The Great Yarmouth third River Crossing

Michael Boon Summary written Evidence

6th October 2019

4.5m Bascule bridge

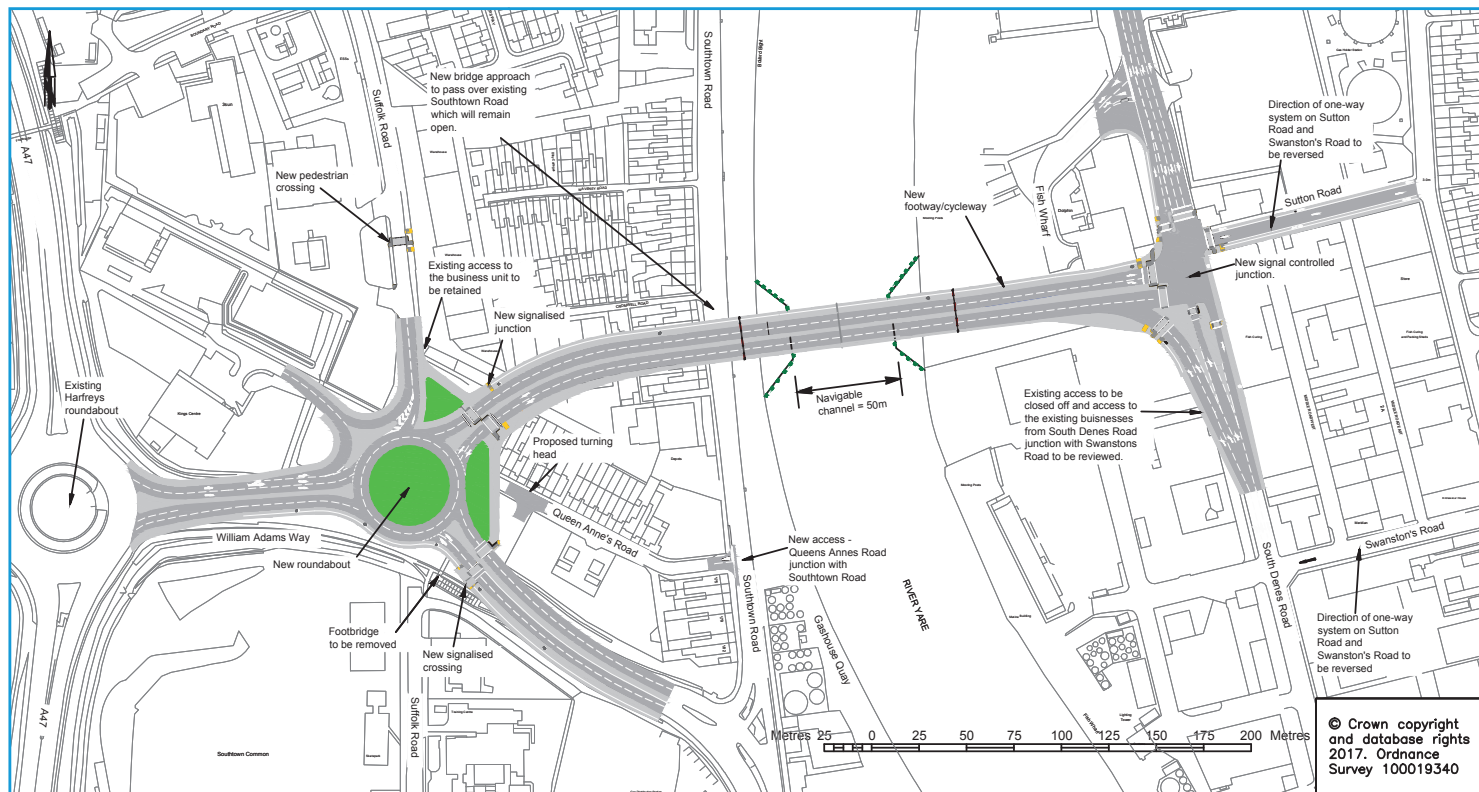
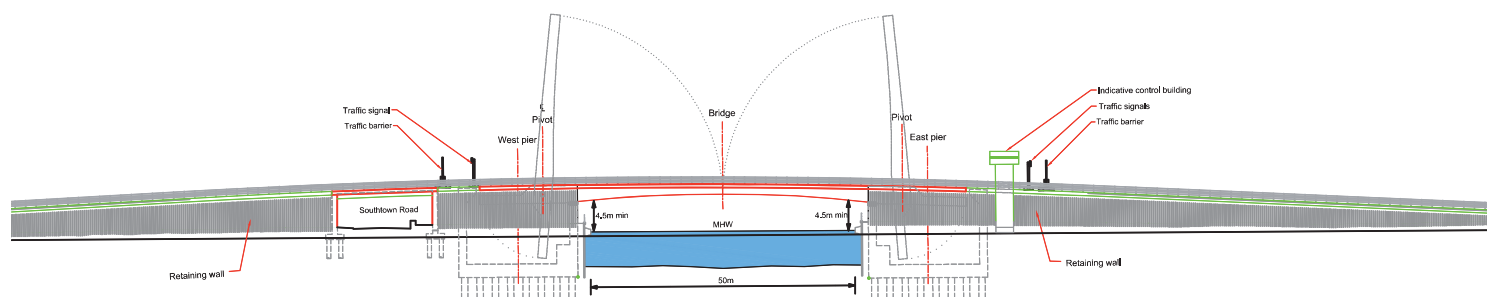
6.1 Having dealt with the Government with regard to the Breydon river crossing during my time in office with the Port Authority I would have preferred to see the scheme with the counterweights above the bridge. It seems that the county council as promoter is favouring one with the counterweights below and no reason has yet been given. I raised the question of the flooding of the ballast chambers during high tides and how this would be dealt with as it occurred at the Haven Bridge but no answer has been supplied. If the ballast chambers were flooded with the bridge be able to operate? Has a different design to mitigate this been thought of? I have not been provided with this information.

8.1 This is one of constraints to navigation by the building of the bridge structure and I have asked what navigable width or other structural constraint is involved in the design and construction of the bridge to vessels passing up and down river and have yet to receive a clear reply on the effect on navigation. I've also asked what the clearance at the top of the lifting spans will be, assuming that they will not be vertical. These are the constraints offered by any proposed bridge. If the lifting leaves do not rise to totally vertical plane then the constriction on the river width will be the difference between the lifted leaves at their full height.

8.2 I have been looking at the vessels currently berthing above and in the vicinity of the proposed construction. It seems to me that some of these have a very wide beam which might prove to make the passage through the spans problematical in difficult tidal conditions.
